Department of Transportation

February 28, 2023

SH 21A/Bradley Road
City of Colorado Springs

RE: Veterans Victory (aka-Villages at Waterview North) {DEPN-23-0002; SUBD-23-0008}

Figure 20  
CDOT/Powers Boulevard Improvements

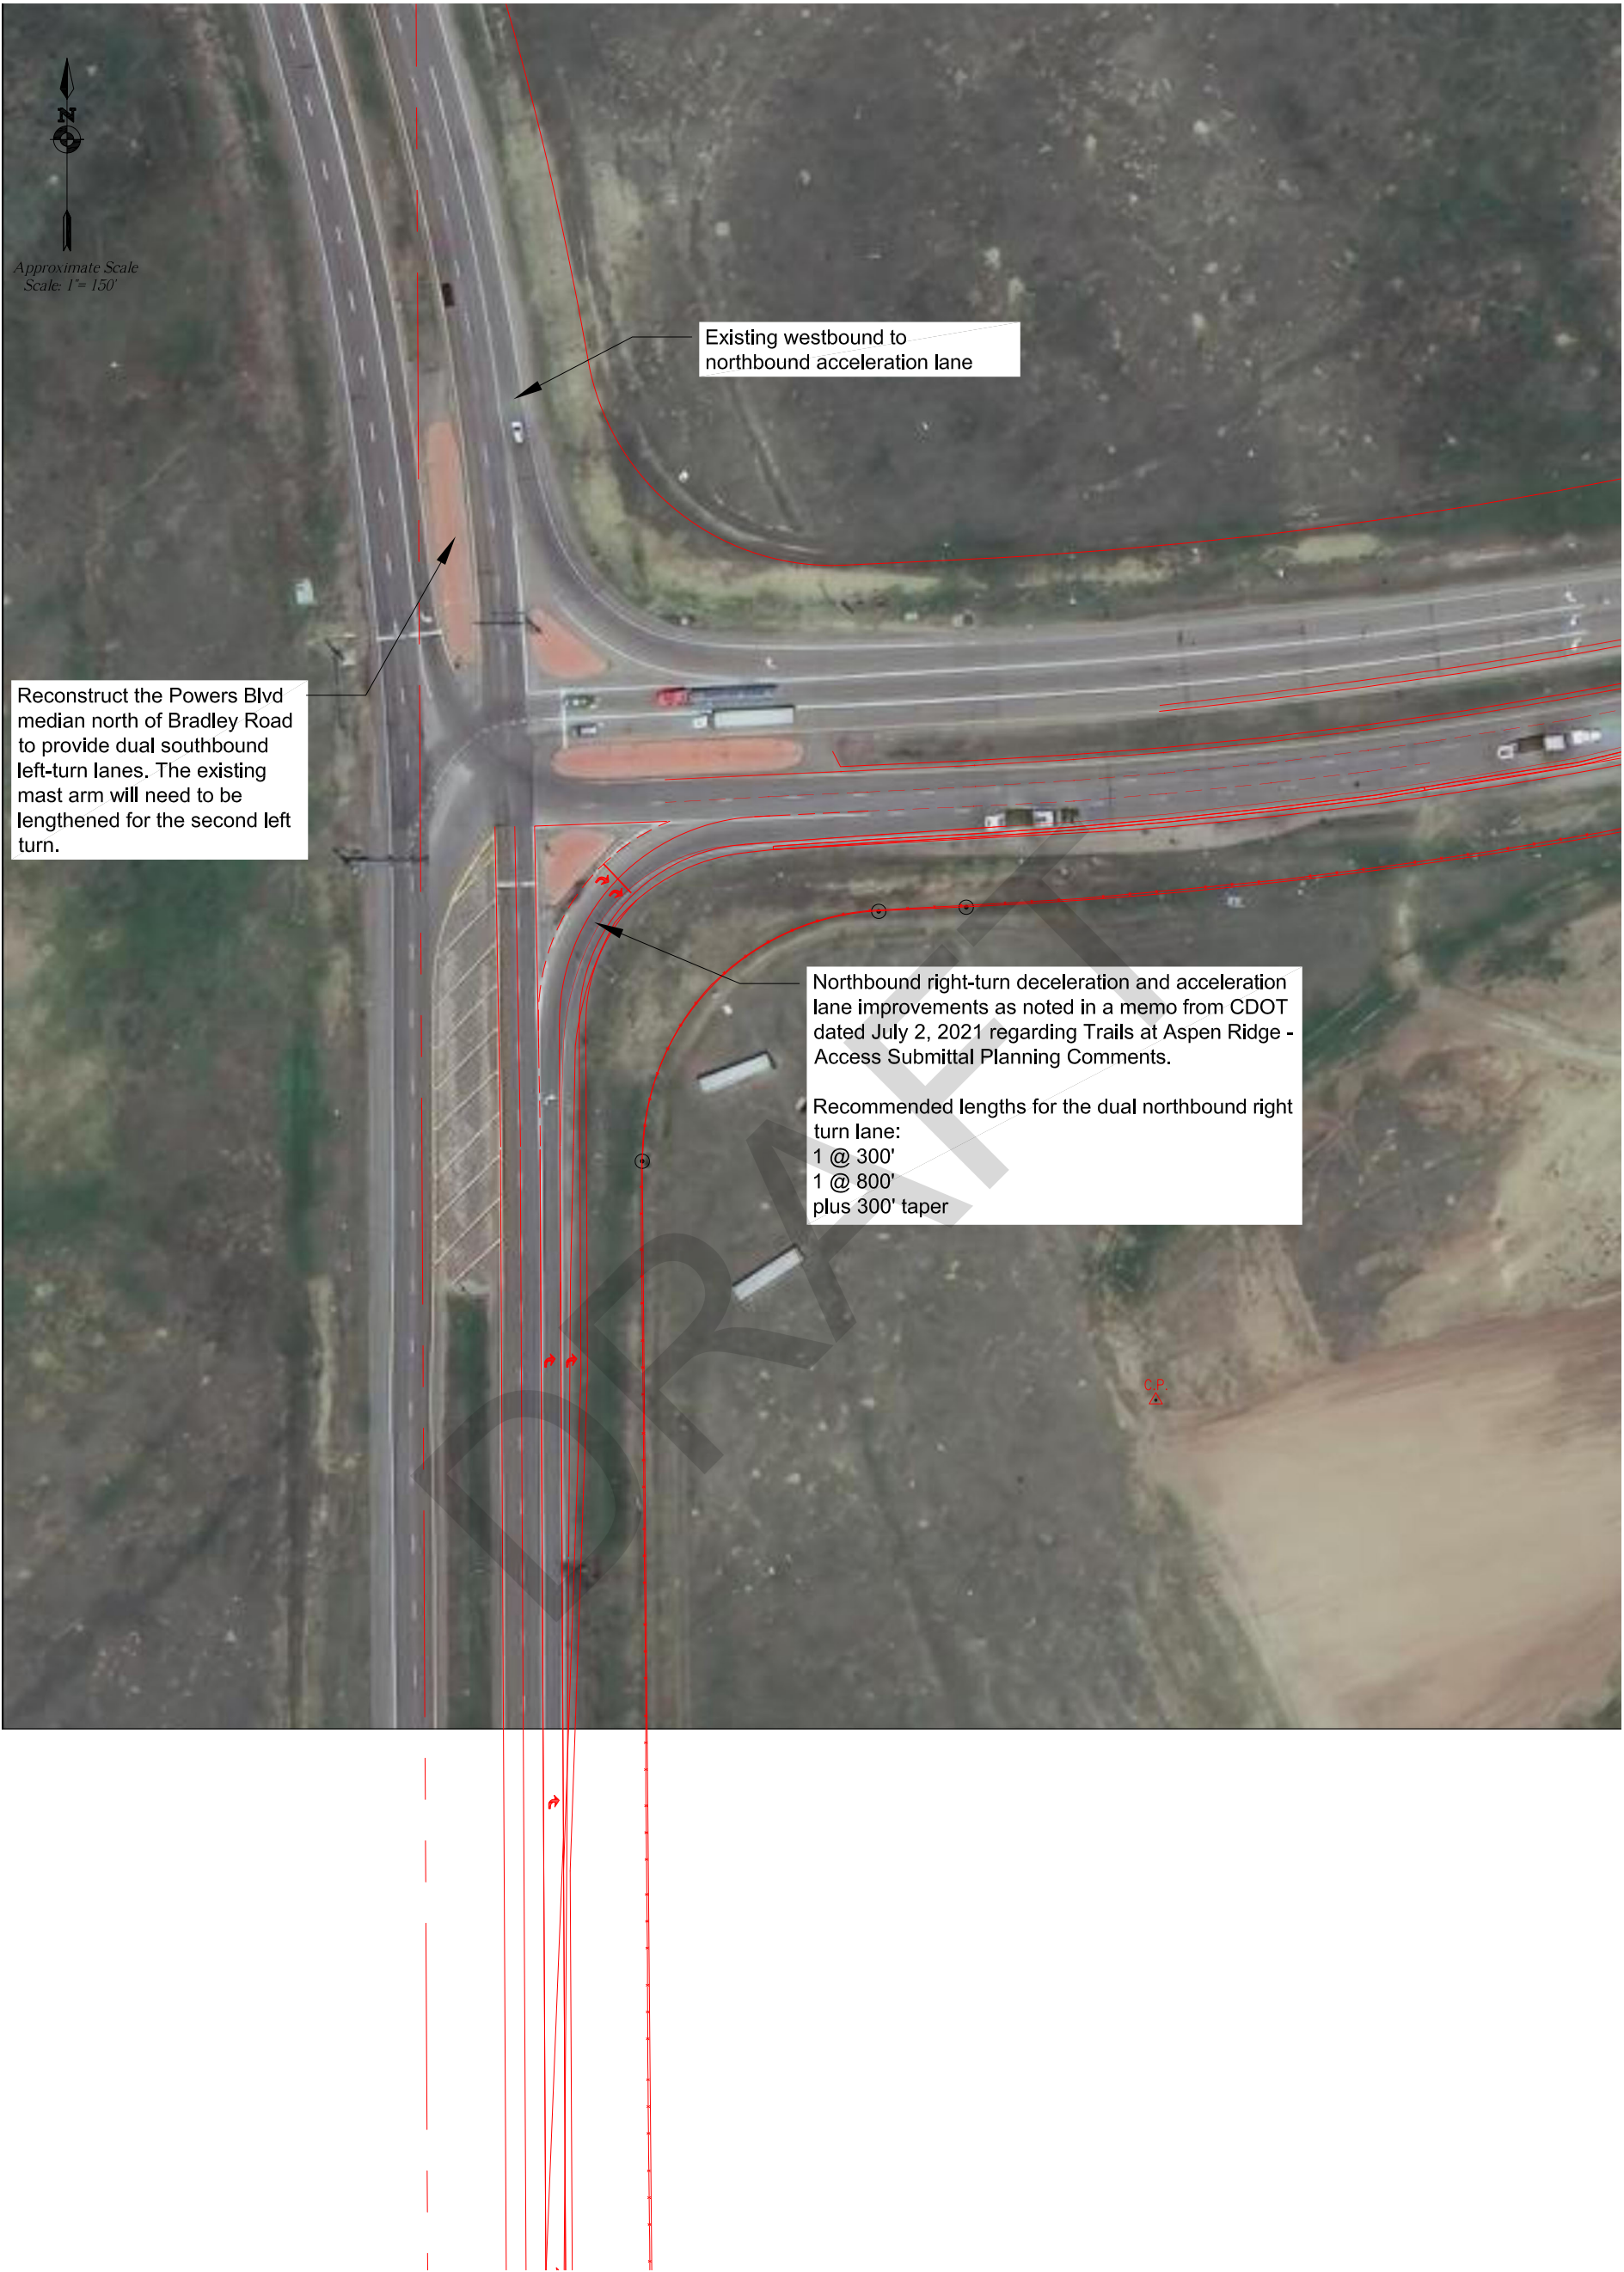
- The following conditions are a requirement for the Notice to Proceed and are agreed upon in TIS (Table 4):
 - a) An additional left turn lane from southbound SH21A/Powers Blvd. to eastbound Bradley Rd. is required to be installed. This requirement creates a southbound dual left traffic movement at the intersection of SH21/Bradley Rd. The construction plans will require adjustment to the existing traffic signal, extending the arm to cover the additional southbound left turn lane. The Development Engineering team will need to confirm that the existing traffic signal pole and caisson can support a longer arm. Otherwise, the entire signal pole will need replaced with the access permit.

- b) An additional right turn lane from northbound SH21/Powers Blvd. to eastbound Bradley Rd. shall be required. This requirement creates a northbound dual right turn traffic movement. Northbound right turning traffic lanes from SH21/Powers Blvd onto eastbound Bradley Rd. shall be signalized controlled. This additional lane requires the roadway widening of this turning movement per the State Highway Access Code.

- c) The northbound right turn lane along SH21 to eastbound Bradley Rd. shall be extended further south to allow for additional queuing for the dual right turn movement onto eastbound Bradley Rd. from SH21a/Powers Blvd.
- d) The westbound to northbound free right turn acceleration lane from Bradley Rd. onto SH21/Powers Blvd. shall be extended to the north to allow for additional merging traffic; refer to CDOT access code for proper acceleration lane length and taper.
- e) A collection of escrow funds shall be required for the developments fair share percentage for future intersection/interchange improvements.

- **Roadway improvements are required by this development and will be detailed in the Access Permitting process with CDOT.**
- **CDOT Access concurs Figure 4 roadway improvements required by this development.**
